(Your Ref: MP10_0177 MOD 6)

**RE: COUNCIL SUBMISSION TO MP10_0177 MOD 7, APPLICATION FOR MODIFICATION
OF MAJOR PROJECT APPROVAL UNDER SECTION 75W**

Re: Emergency vehicle access for residential development Meriton Development in Warriewood Valley.

CUL-DE-SAC - ROAD 01
SCALE 1:250

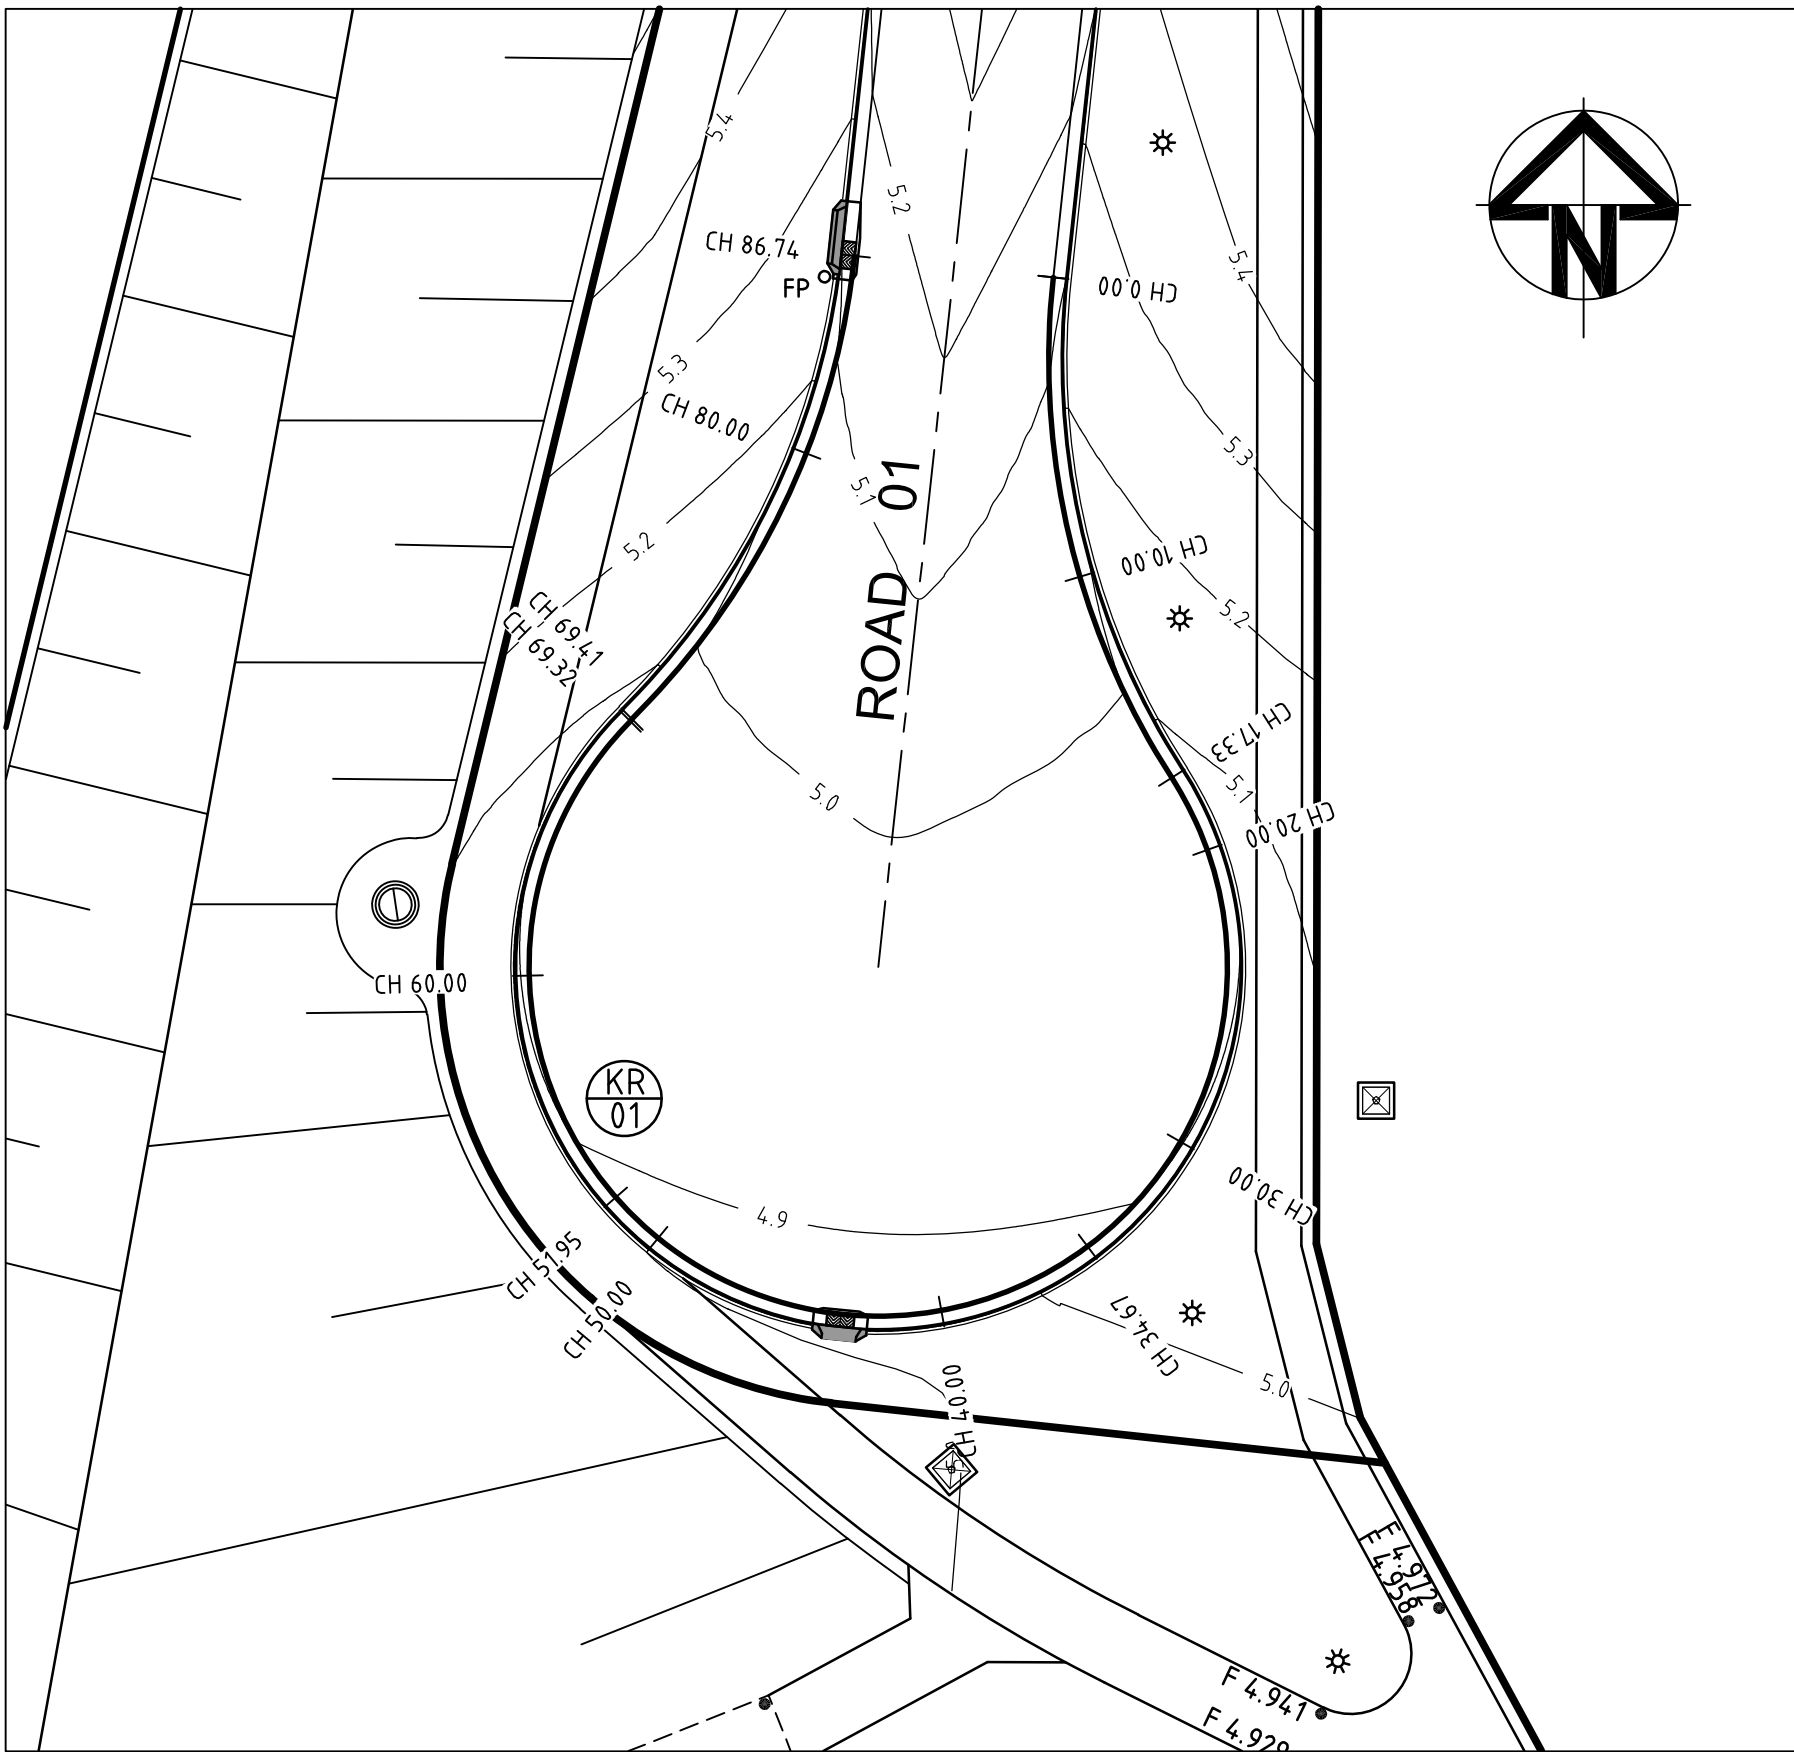
The current 3m proposed width of the straight and curved carriageway sections on the SKC22 plans are insufficient for continuous access of FRNSW appliances in a forward direction. It is also noted that access to the proposed road from the western cul-de-sac appears to be even narrower and may be impossible for emergency vehicles to enter or exit from.
